Application No: AL/63/20/HH  
Site Address: Long Acre Littleheath Road Aldingbourne BN18 0SR  
Description of works: Single storey and two storey rear, side and front extensions including re-roofing and re-fenestration work.

Thank you for your internet representation made on 8th September 2020 which has been recorded as an objection with the comments as follows:

Proposed Extensions and Alterations
at
Long Acre, Little Heath Road, Fontwell
for
Mr and Mrs G Devenish
Drawing PL13 August 2020 Scale 1:500 @ A3
Planning Drawing - Block Plan

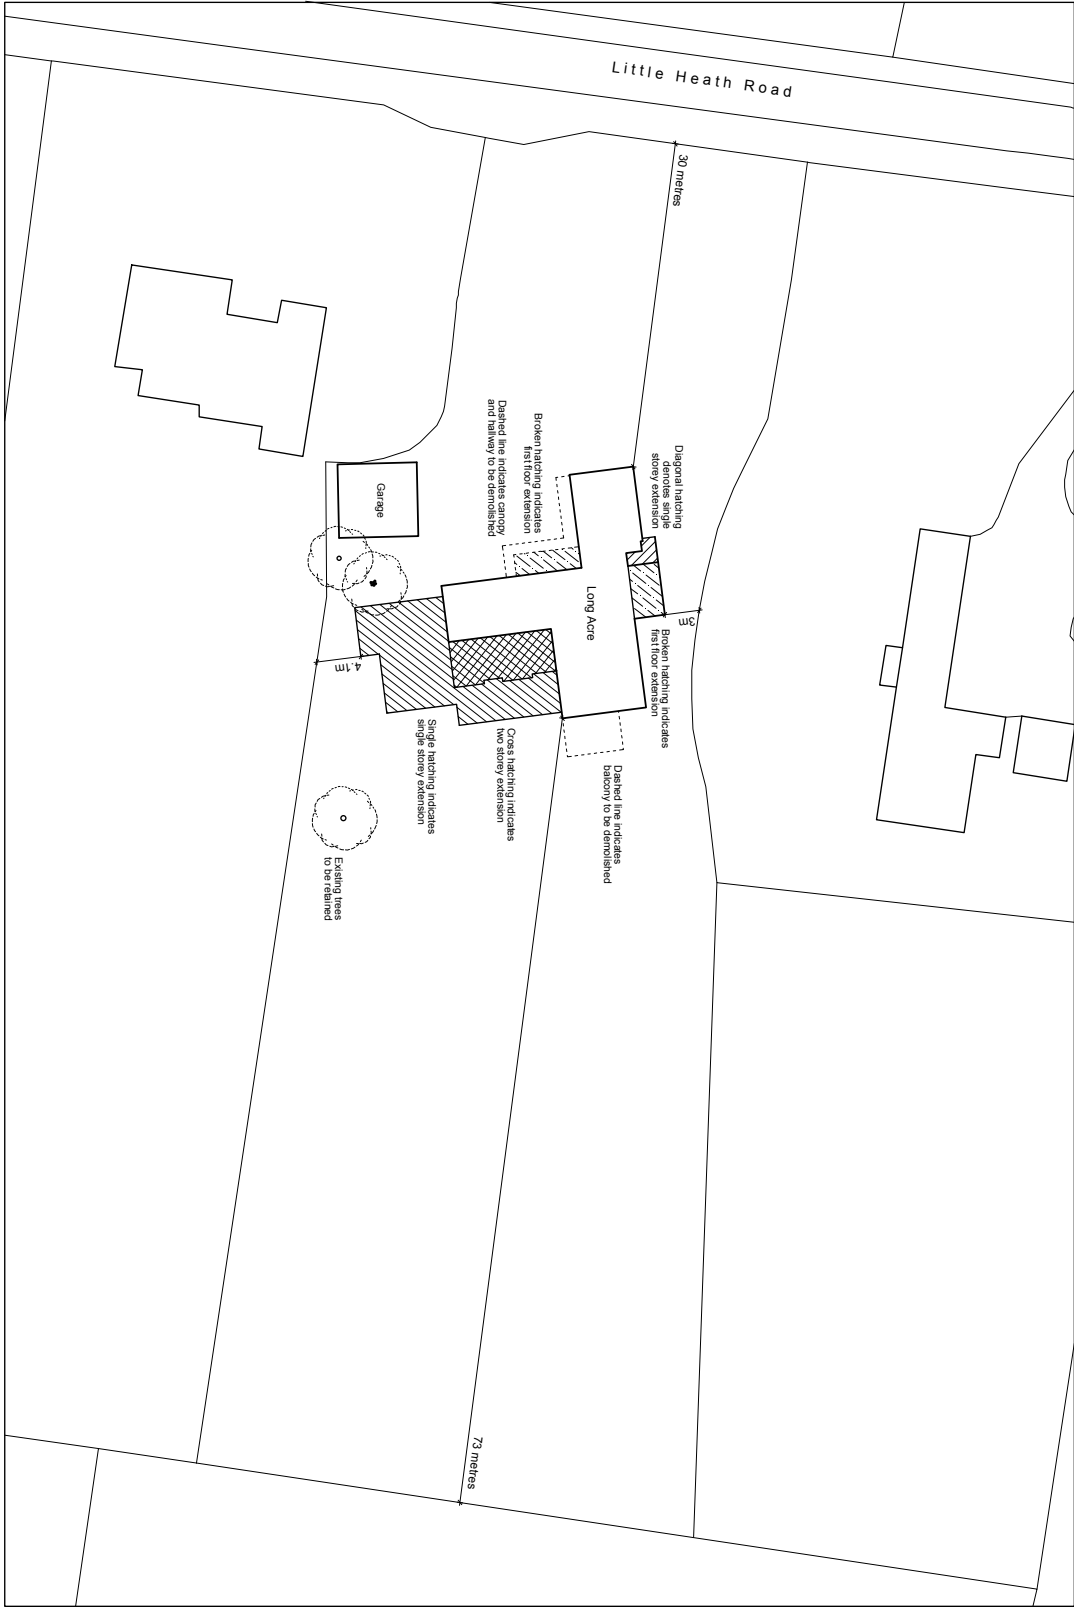
Importantly, the site plan appears to be based on an old OS map which does not show our garden room, which means that our house is considerably closer to the boundary than it appears on the plan. The proposal for the north wall of Long Acre appears to be inaccurate in that it is already considerably closer to the boundary than is indicated on the plans and the new building will be substantially closer to our boundary than the 3 metres indicated. This area between our two houses is important to us; as well as our south facing garden room we have an adjacent sitting area facing south. The current prospect looks at a setback brick wall and chimney; its proposed replacement by a monolithic 2 storey wall with render is a disappointment and will spoil this important view. This is not acceptable.

North Elevation

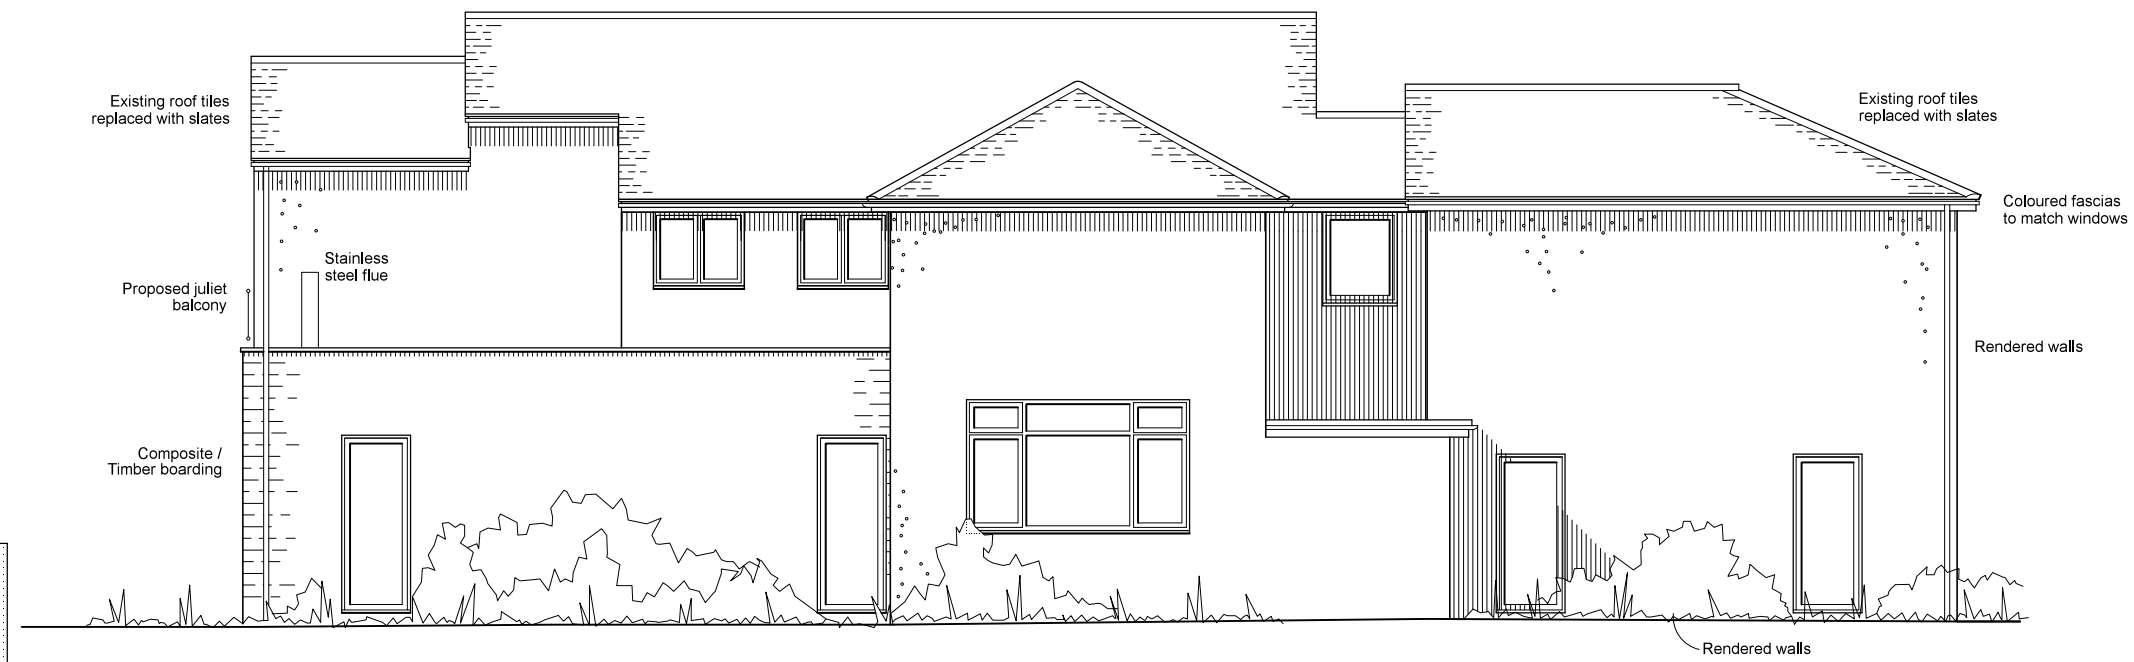
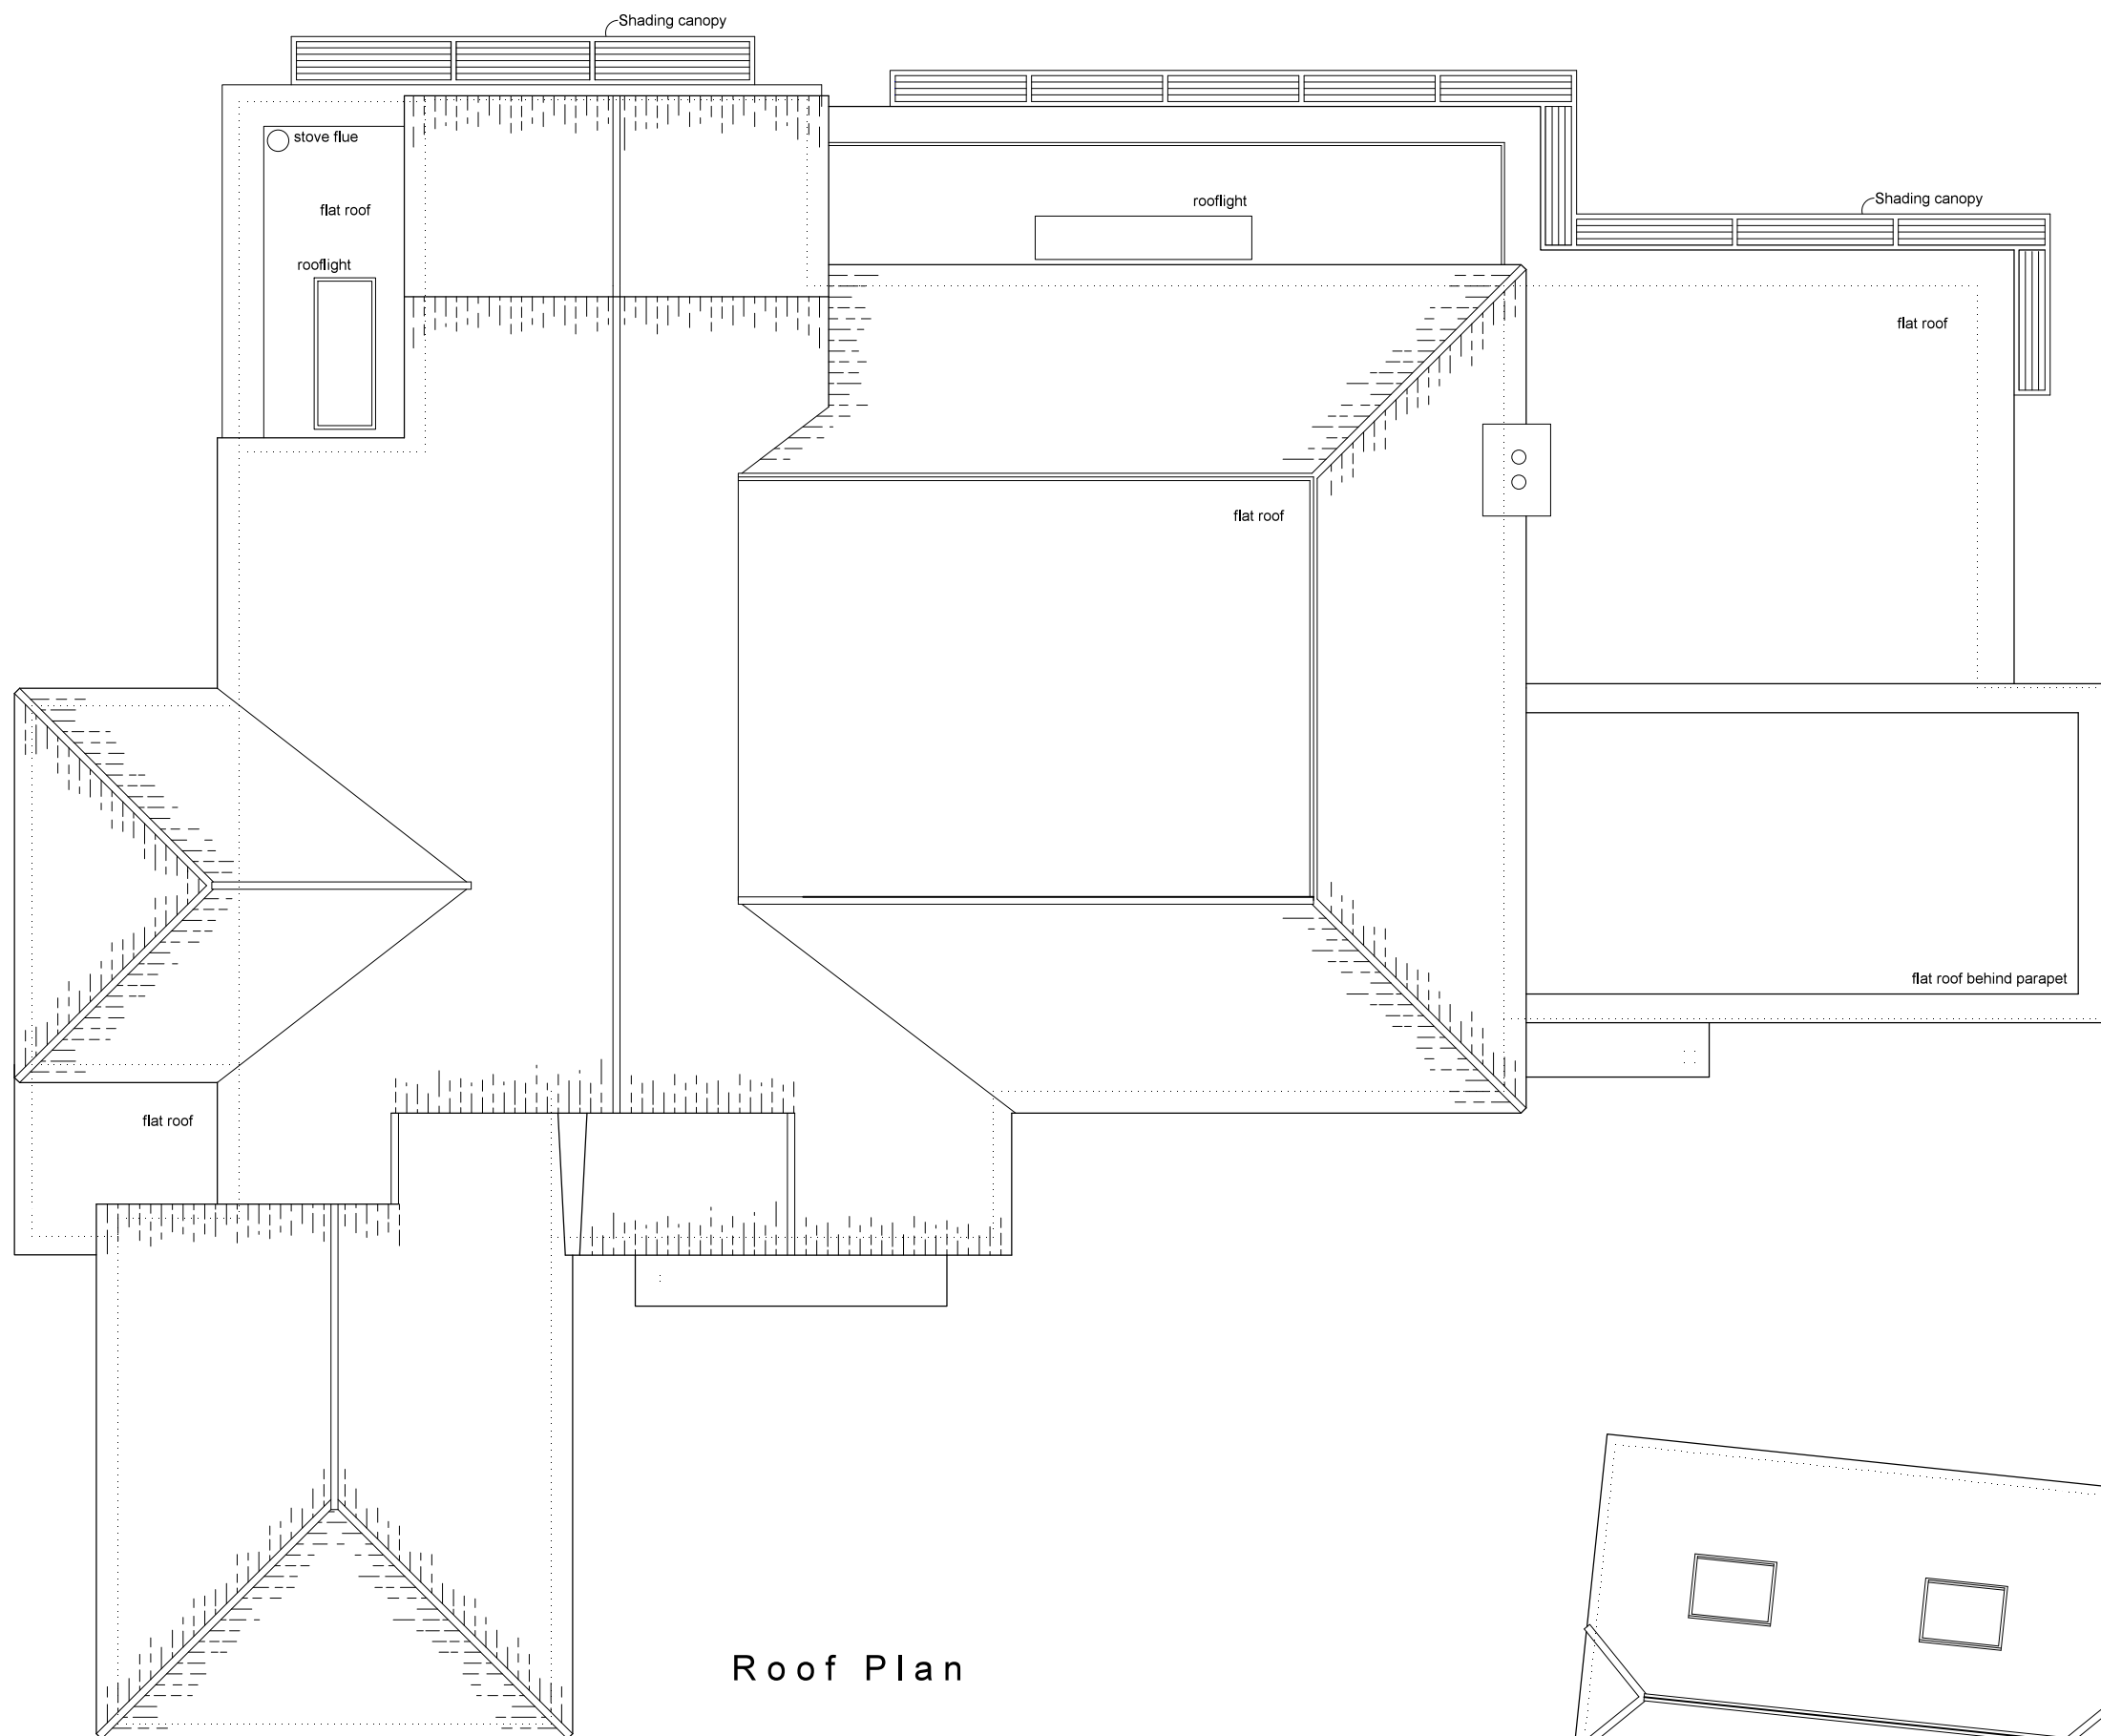
Having examined the application, the proposal for the north elevation of Long Acre would appear to have a considerable effect on my property because it is very close to the boundary and the increase in height prompts a concern about possible overlooking as well as concern about the new silhouette and loss of daylight and sunlight.
